Planning Application Ref: AW / 284 / 13 / T

Location : Various Locations in Kingsway, Craigweil Estate PO21 4DH - Mr R Lock

Description of work:

T 5  
GOLDEN LEYLAND 11

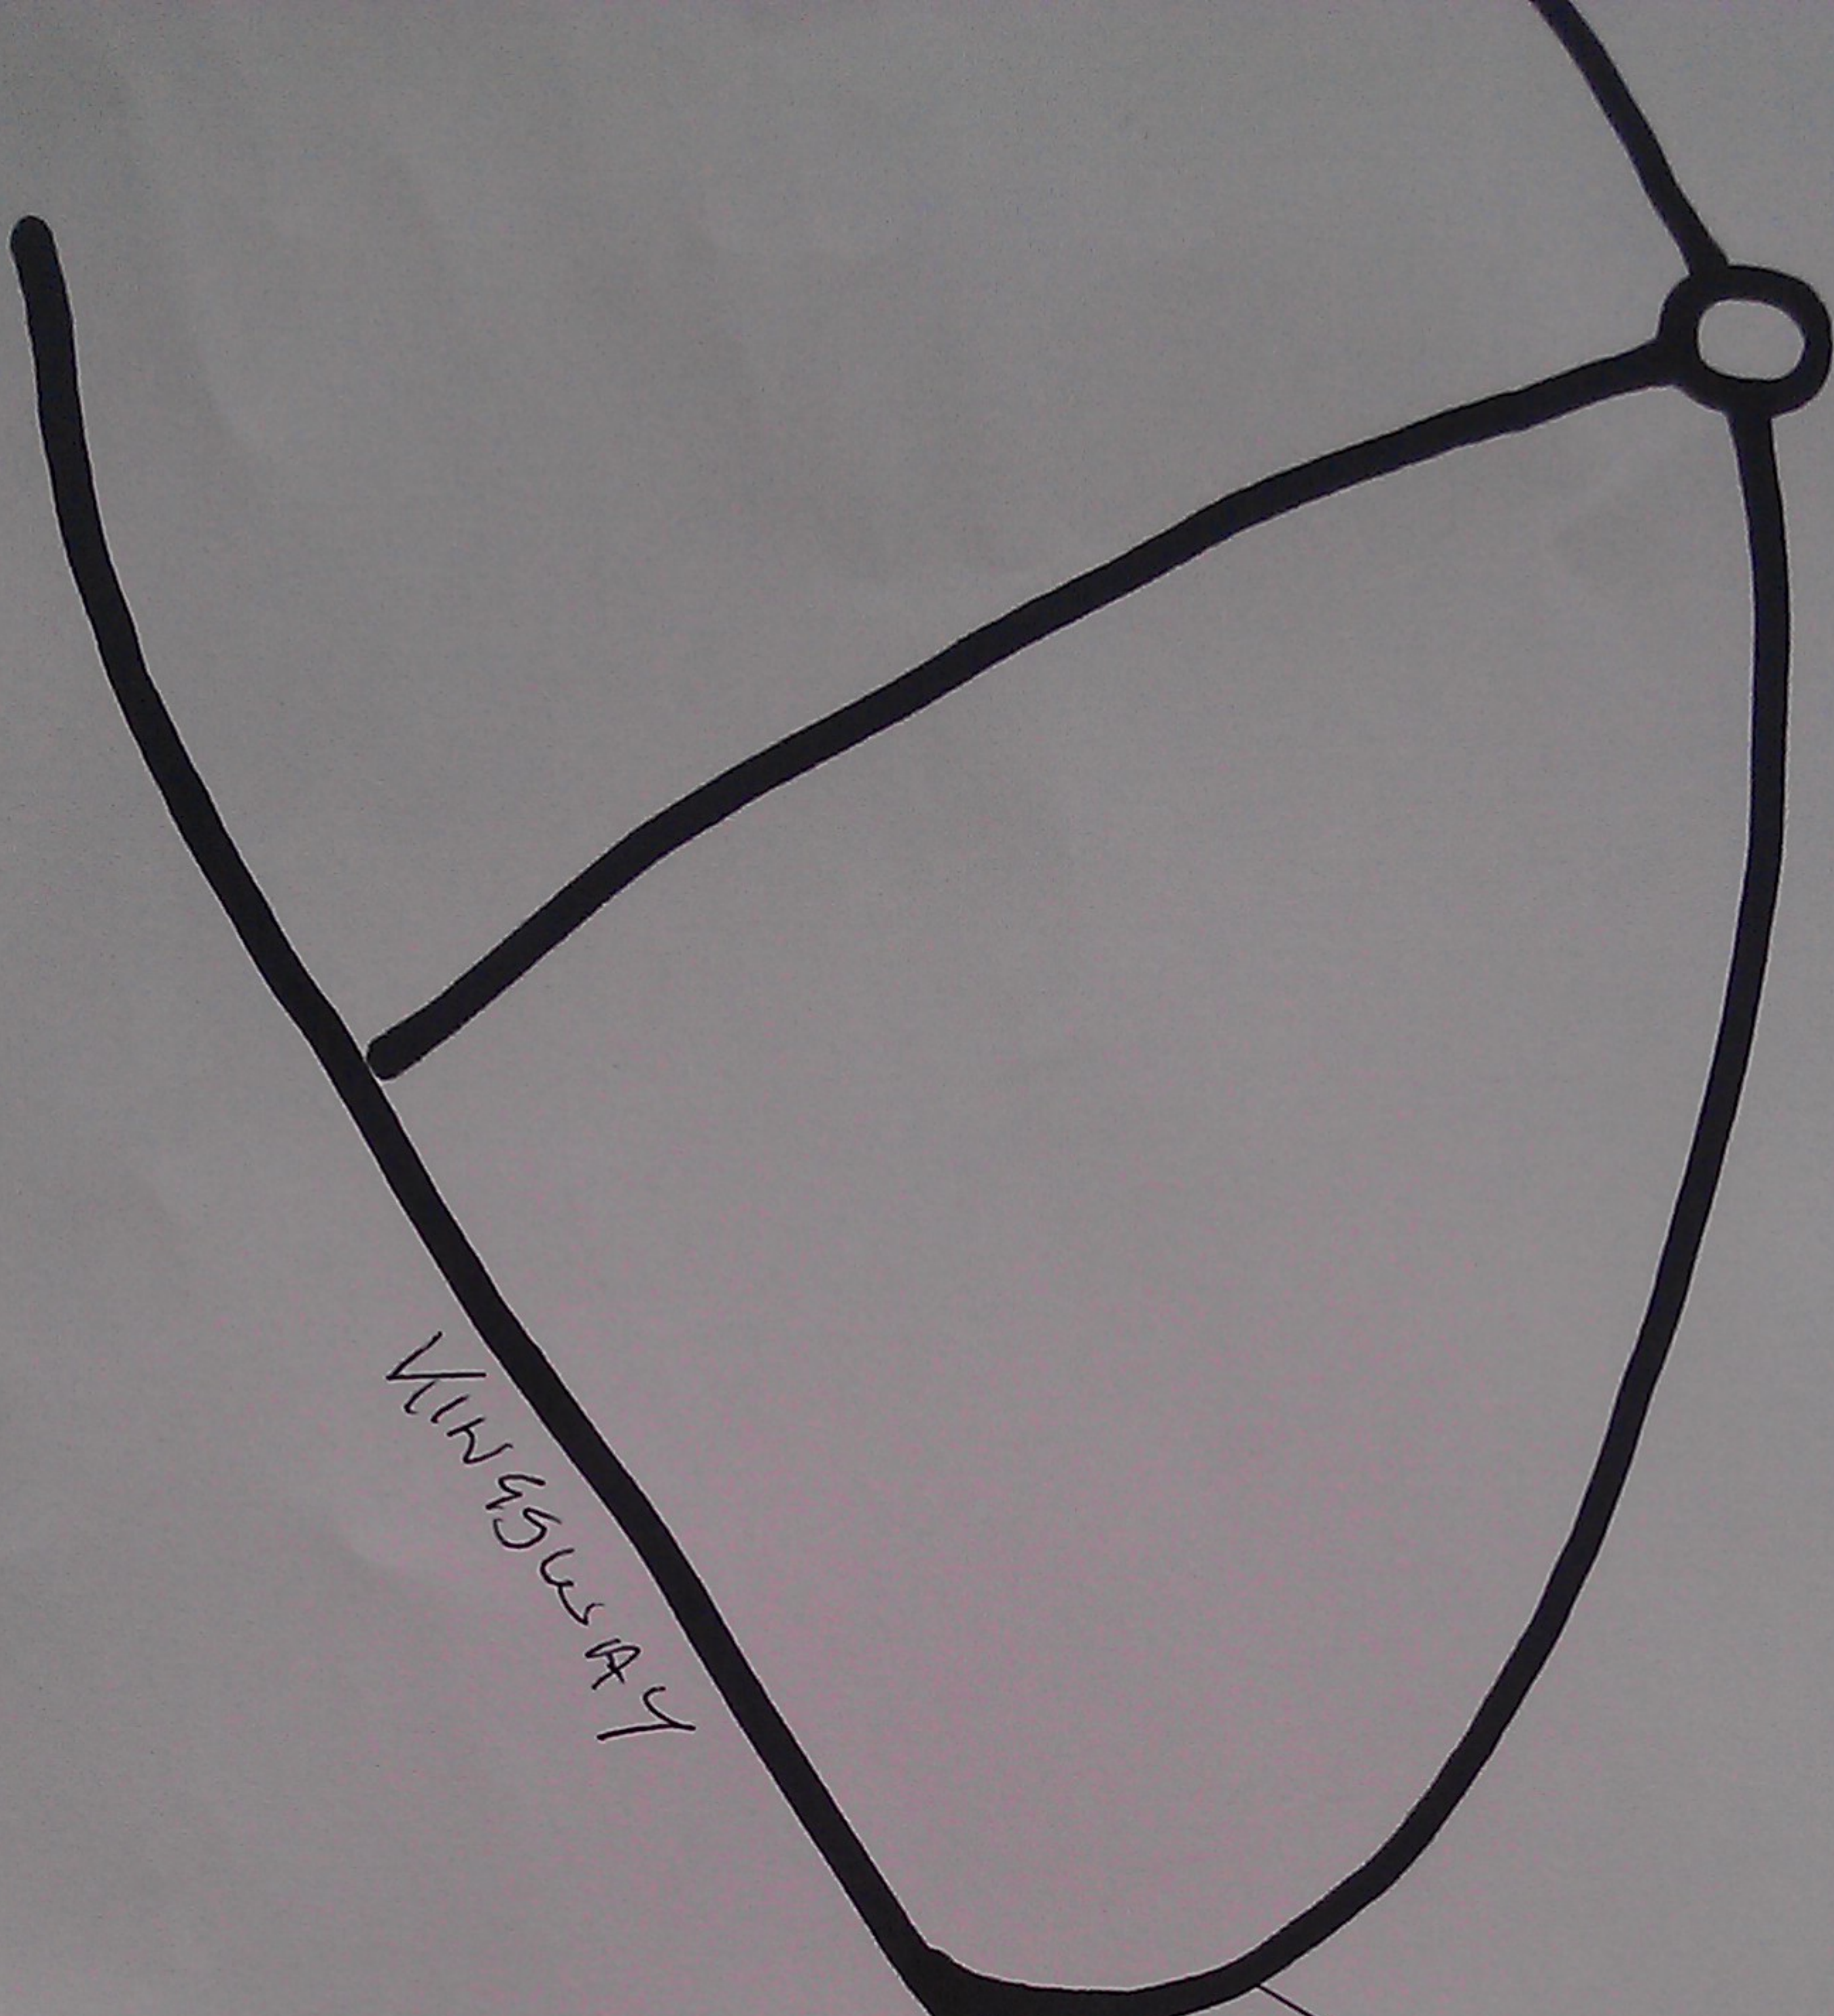
T5 – Golden Leylandii Height = 4.5 Average radial branch spread = 2m Age = Young

The problem of footpath overhang could be dealt with by pruning but I have no real issue with the removal of this conifer as the gap in the hedge will soon be closed by the growth of the Yew and Laurel which are better plants for the future – no replacement tree is required in this instance.

T5 – Golden Leylandii - no objection + no replacement tree required
